CITY OF ALBUQUERQUE

Re: Kennan Properties
12900 central Ave SE, Albuquerque, NM 87123
Traffic Circulation Layout
Engineer's Stamp **05-15-18** (L22-D061)

Based upon the information provided in your submittal received 05-15-18, the above referenced plan cannot be approved for Building Permit until the following comments are addressed:

TRAFFIC CIRCULATION PLAN

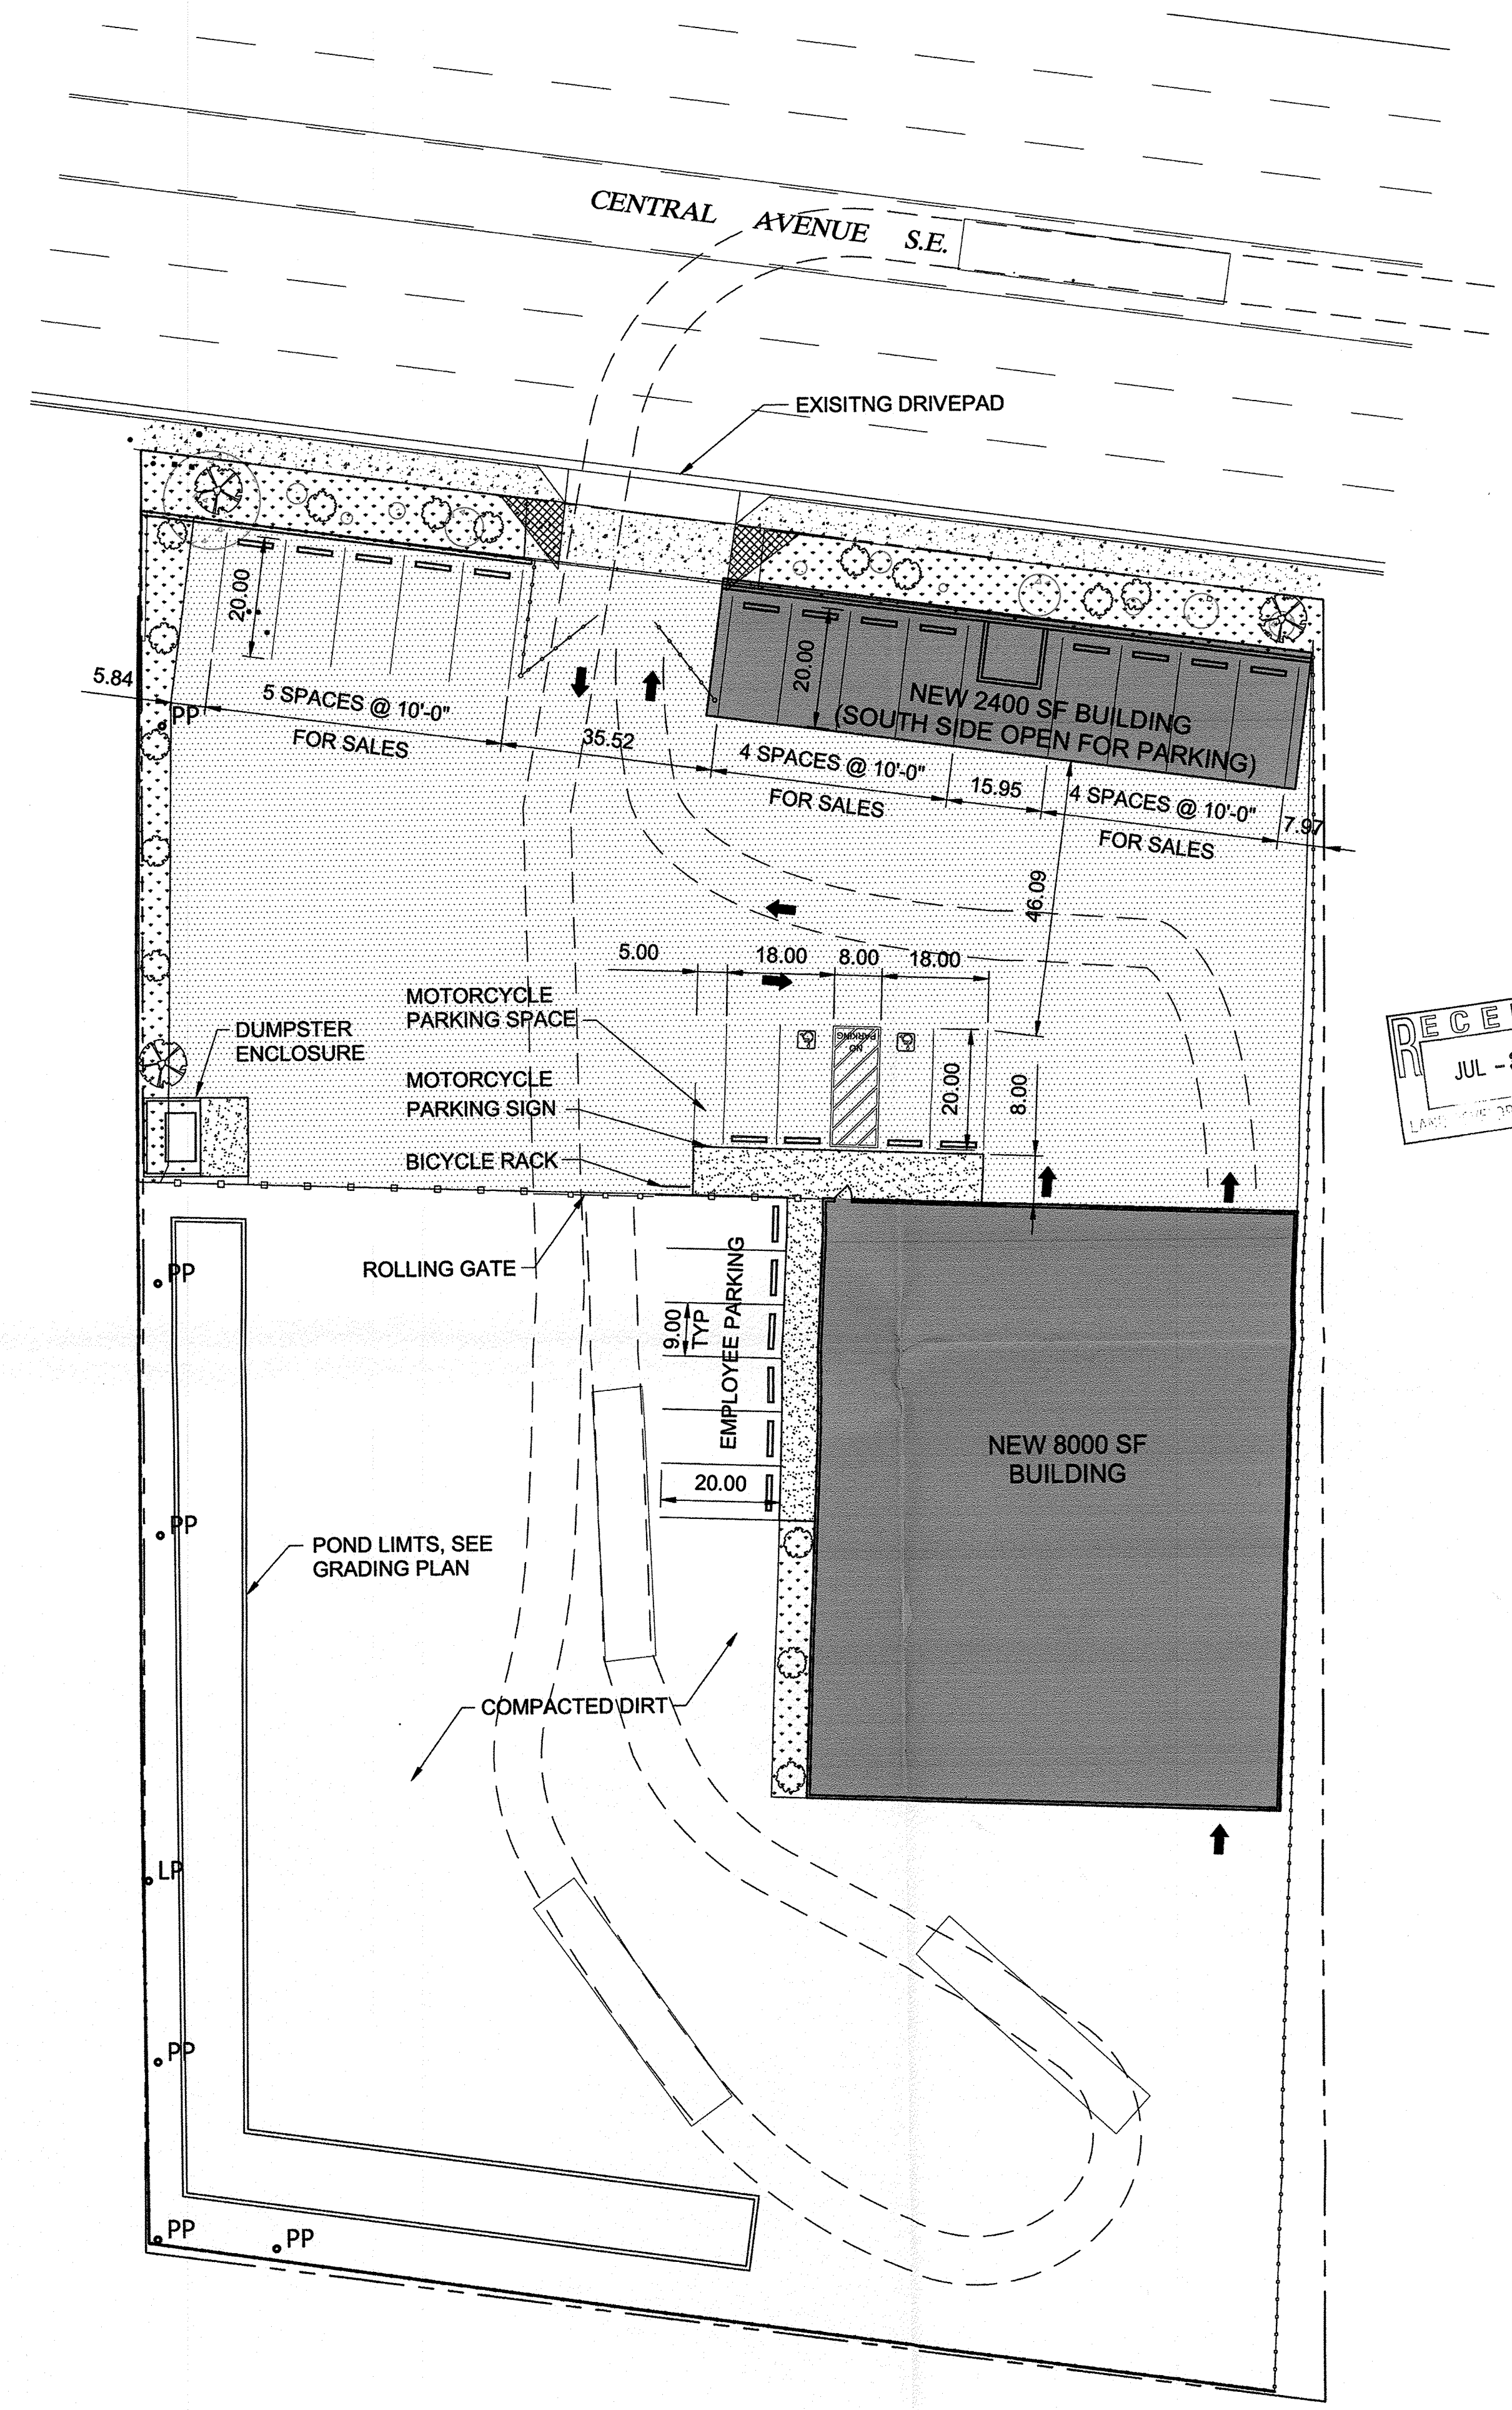
1. Please dimension the length of the existing and proposed parking spaces.
2. It is not apparent what type of pavement surface is being proposed. A hard driving surface will be required as part of this proposed project for parking area and drive aisles.
3. A 5 ft. keyway is required for dead-end parking aisles. Please show the 5 ft. dimension at the end of the parking rows.
4. Please clarify what the shaded area over the parking spots indicates.
5. The number of the parking in the drawing does not match the number mentioned in the legend. Please update the provided parking calculation.
6. There are 6 parking bumpers are shown at the west side of the building. Please indicate if they will be used for additional parking.
